Job No. 192628

July 13, 2023  
Revised July 24, 2023

Re: Wastewater Study  
Meadow Lake Industrial  
Section 9, Township 15 South, Range 65 West  
El Paso County, Colorado

PRELIMINARY PLAN

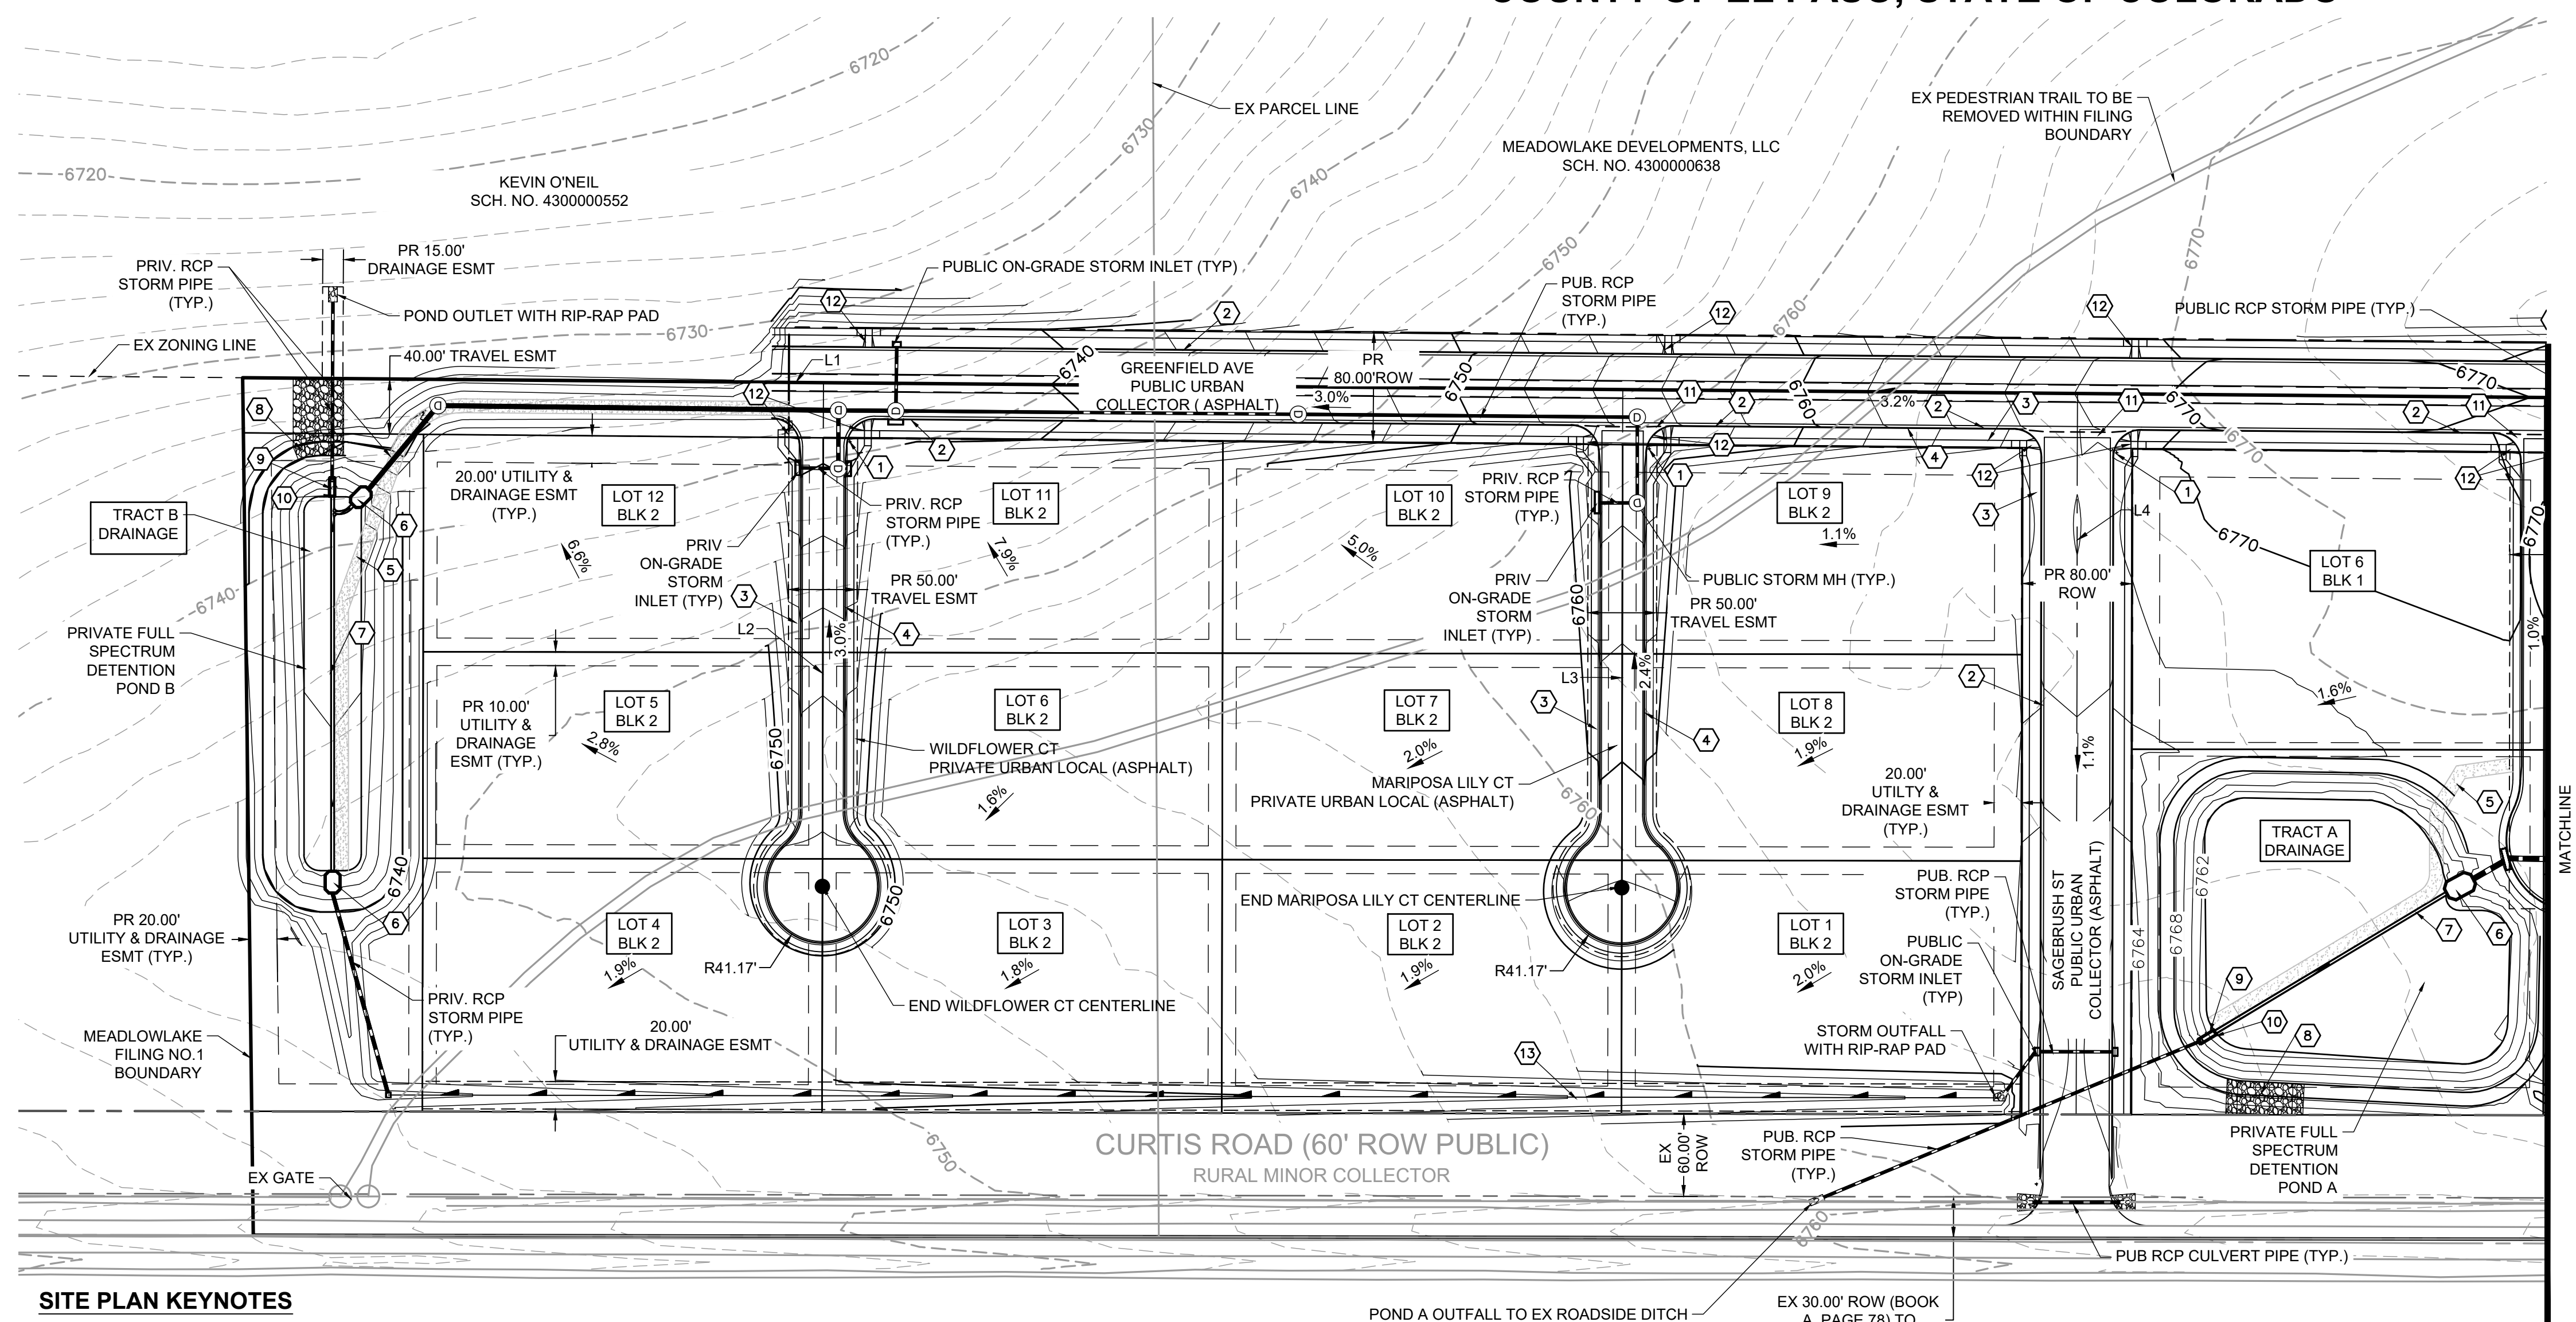
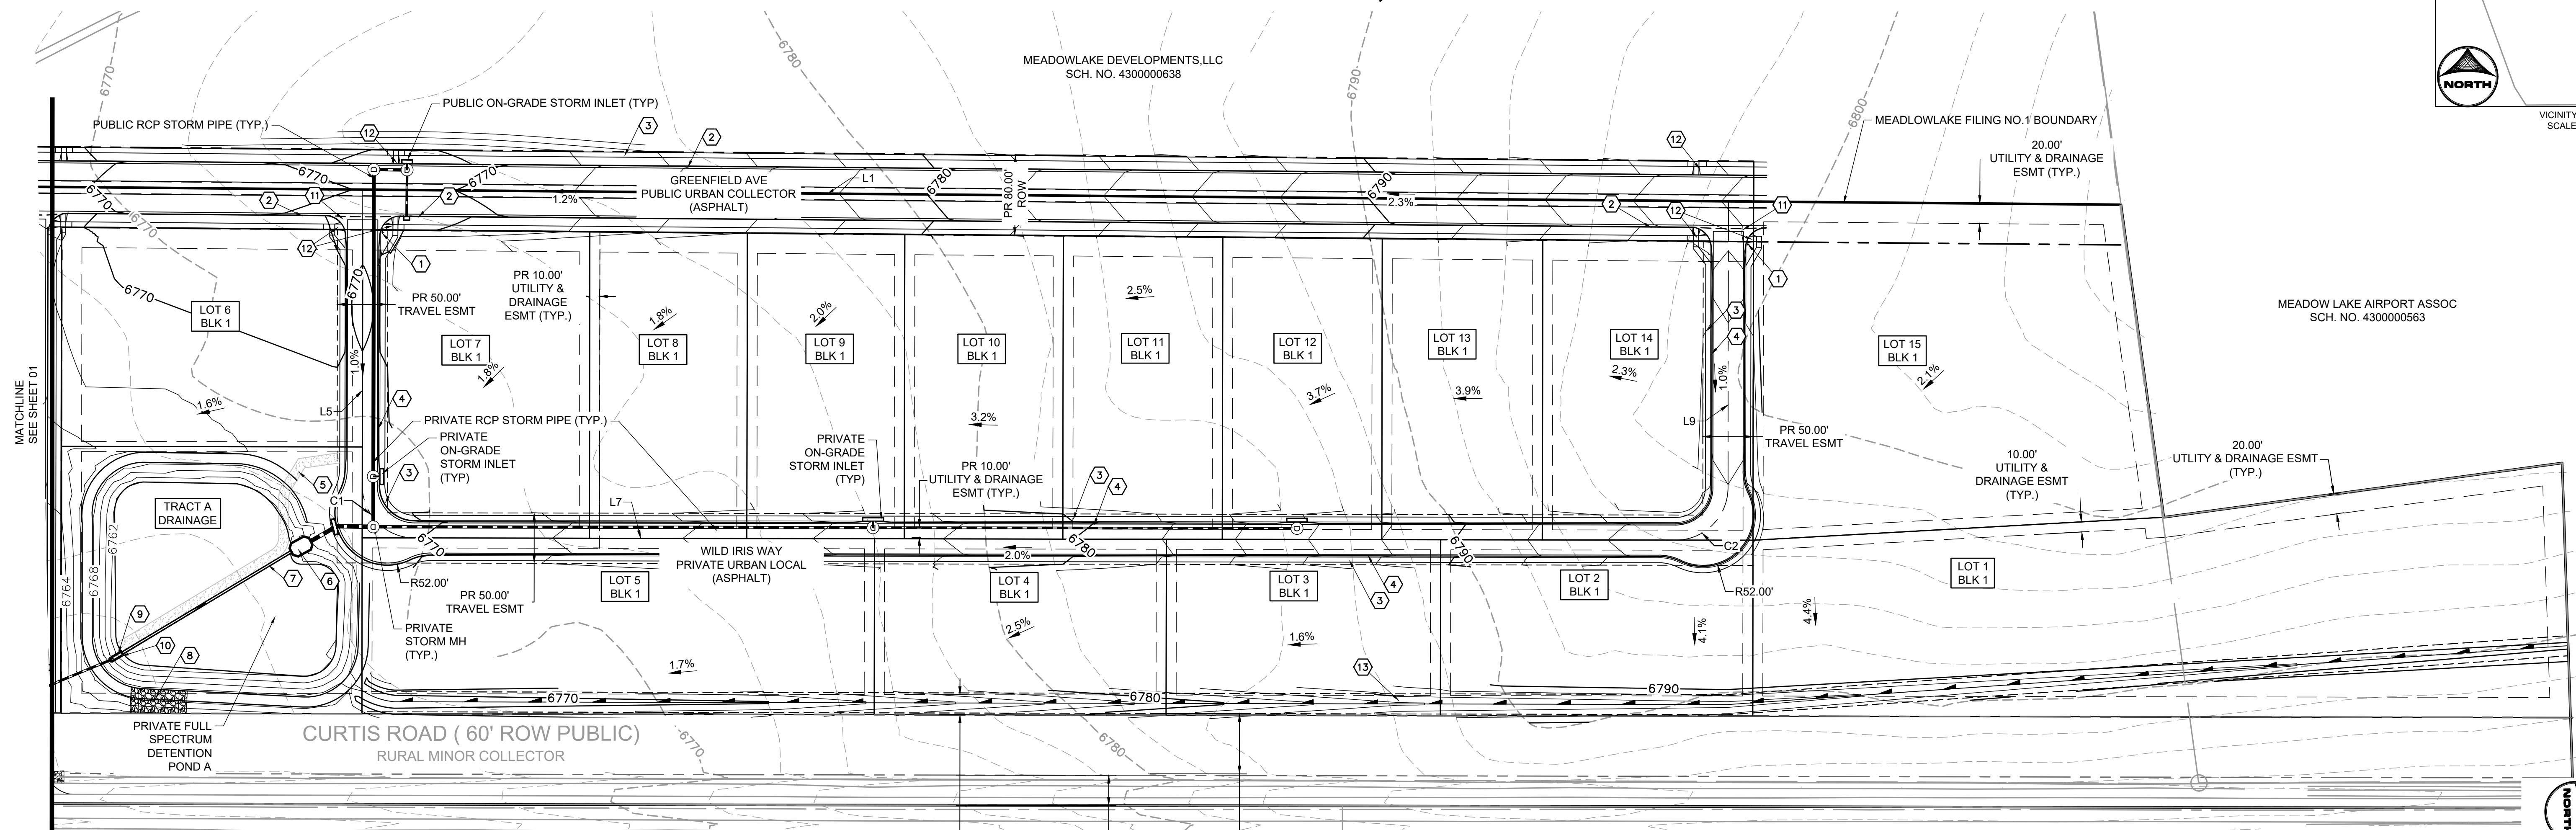
Please provide a map depicting the proposed OWTS locations.

This is not the correct number of lots. Preliminary plan depicts 27 lots and two tracts. This is probably not a critical comment, but it does misrepresent the number of proposed developable lots, so I would recommend updating the language for clarity.
